Rezoning Transportation Analysis

Petition Number: 2022-151

General Location Identifier: 02711418

Date	Description
1-25-23	First Review (TM)
03-23-23	Second Review (TM)
04-20-23	Third Review (TM)
05-24-23	Fourth Review (TM)

DRAWING NUMBER:
RZ-1

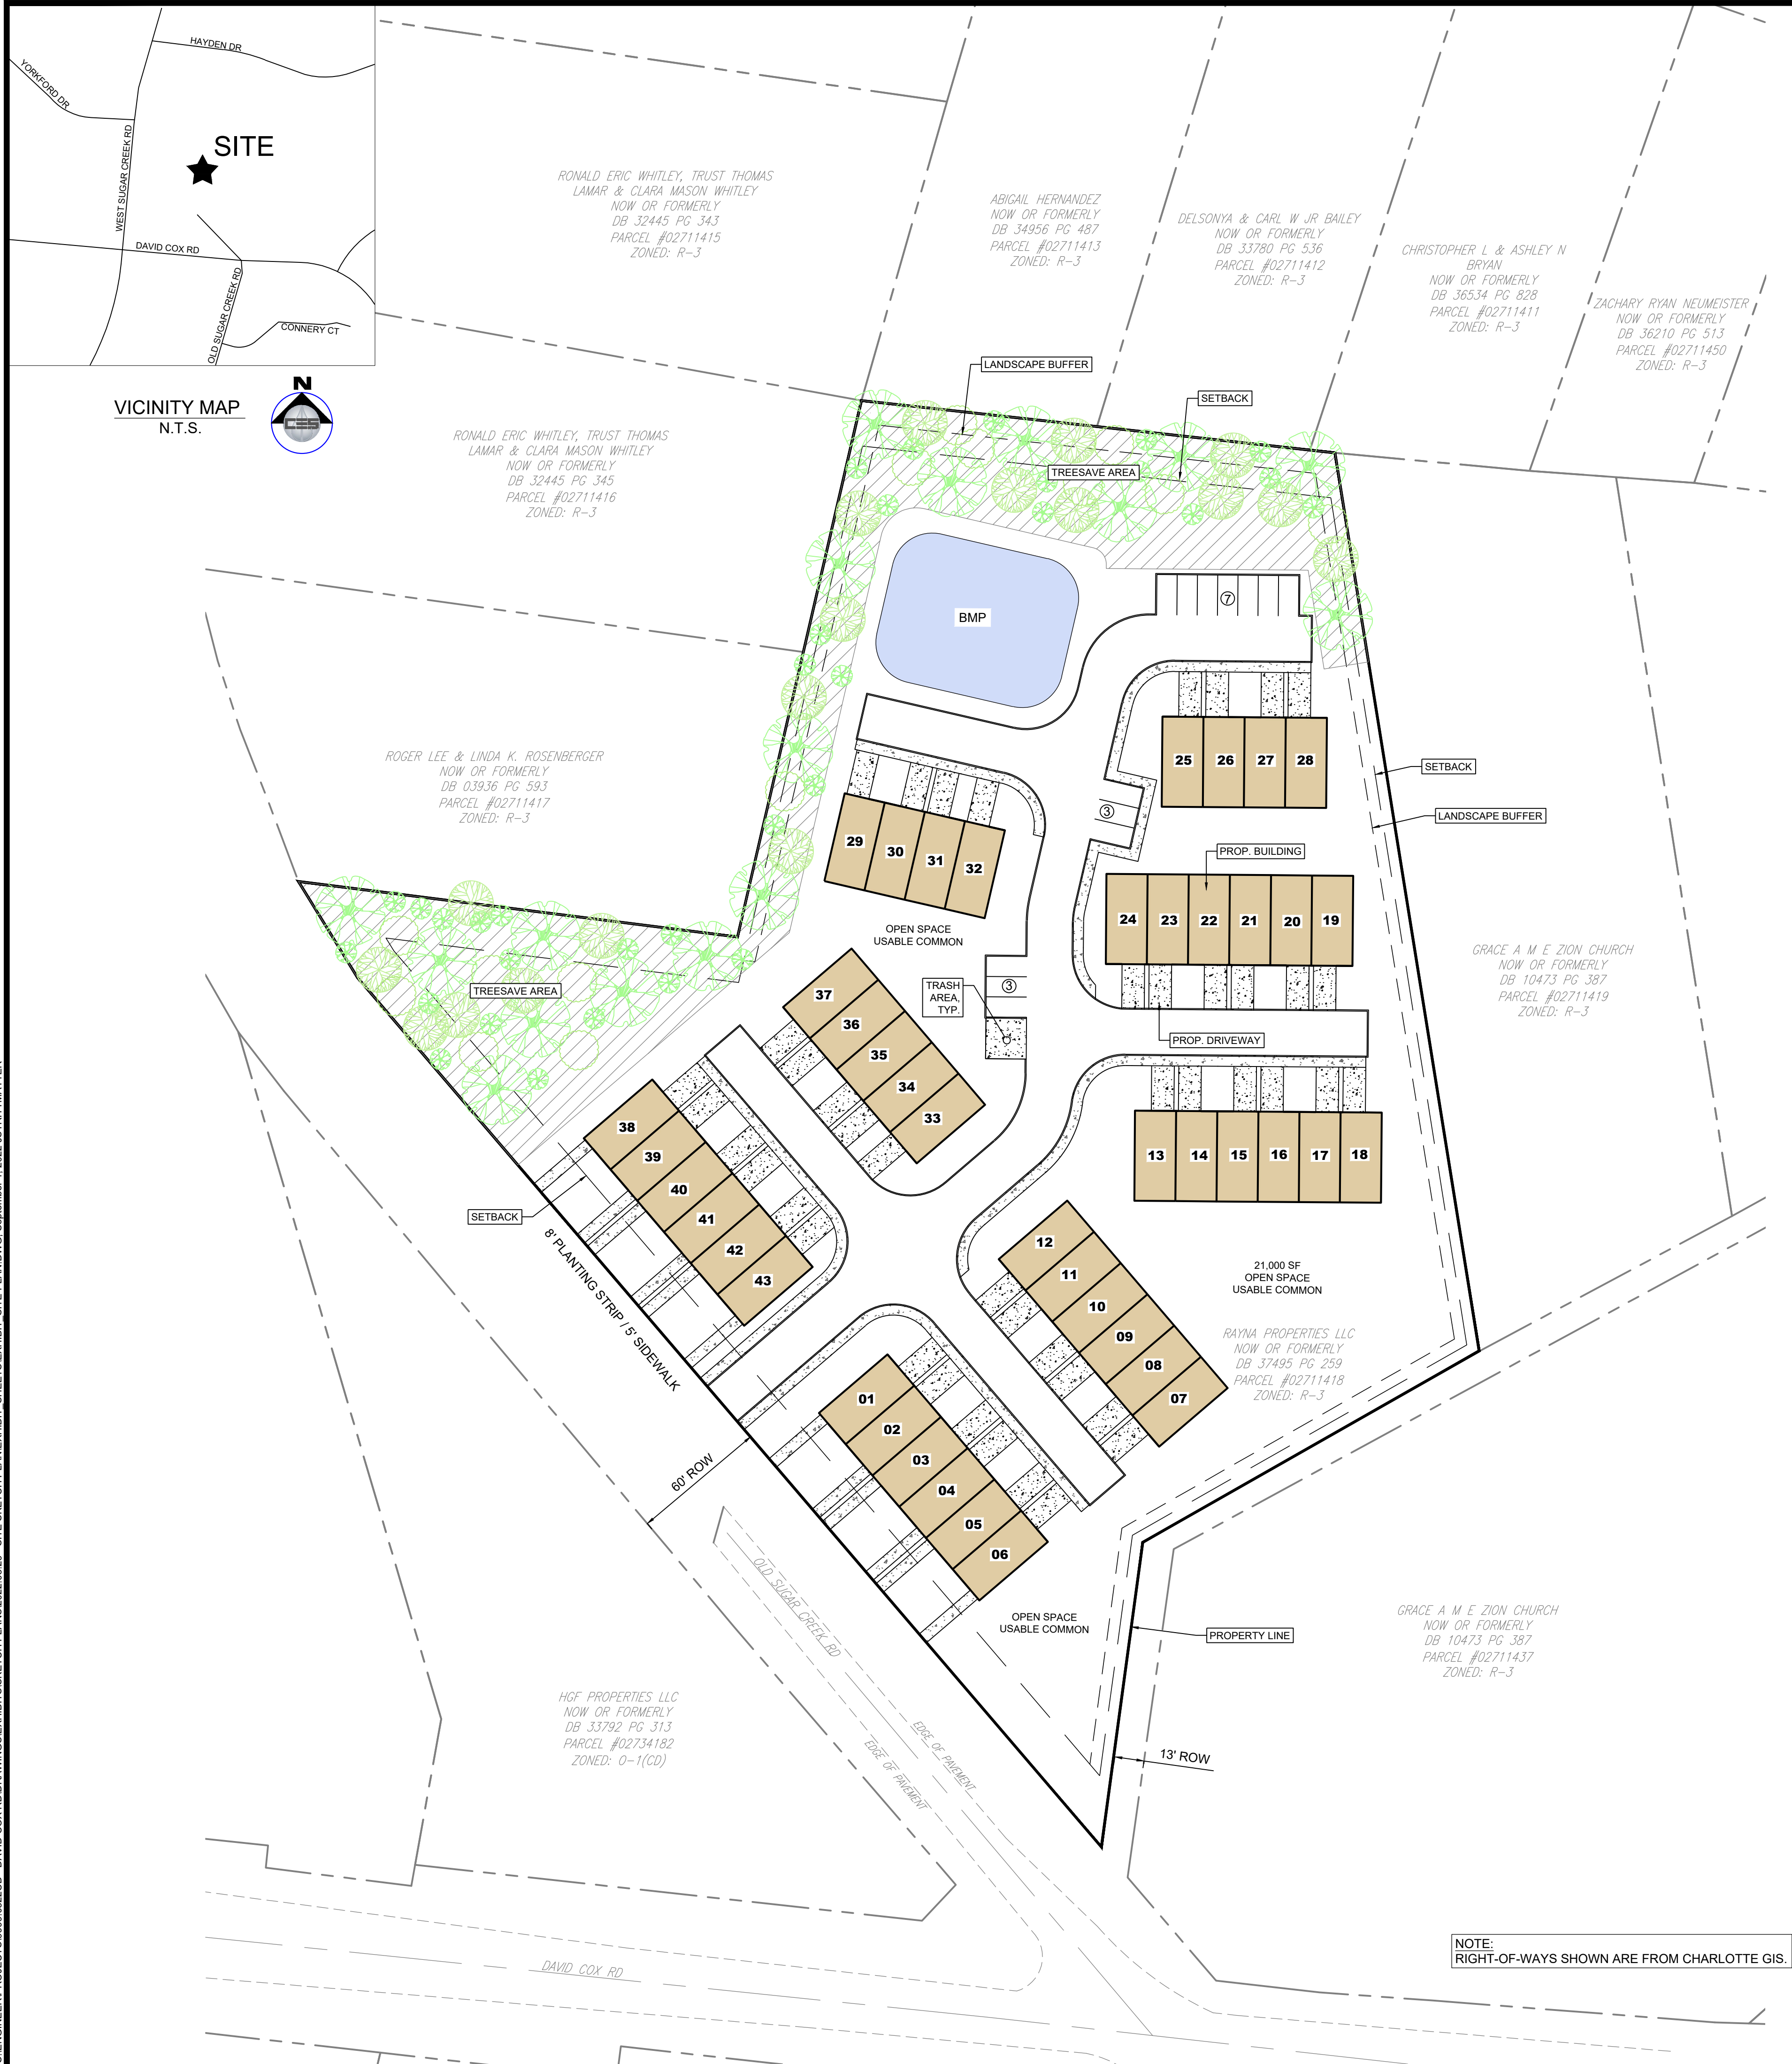
Clarifying Comment 03-23-23: Revise site plan by labeling the proposed public street extension per CLDSM U-02, dimension back of curb from roadway centerline and add dimensions of sidewalk on site plan.

10. **NEW COMMENT 03-23-23:** Revise site plan by labeling all internal proposed streets as private.

11. **NEW COMMENT 04-20-23:** Revise conditional notes by modifying the conditional notes to reference the proposed roadway in lieu of Old Sugar Creek conditional notes as Old sugar creek is to be abandoned (see above comments regarding abandonment). Conditional notes are to reference the proposed roadway and not Old Sugar Creek.

12. **NEW COMMENT 04-20-23:** Revise site plan to remove extension of private streets to property line.
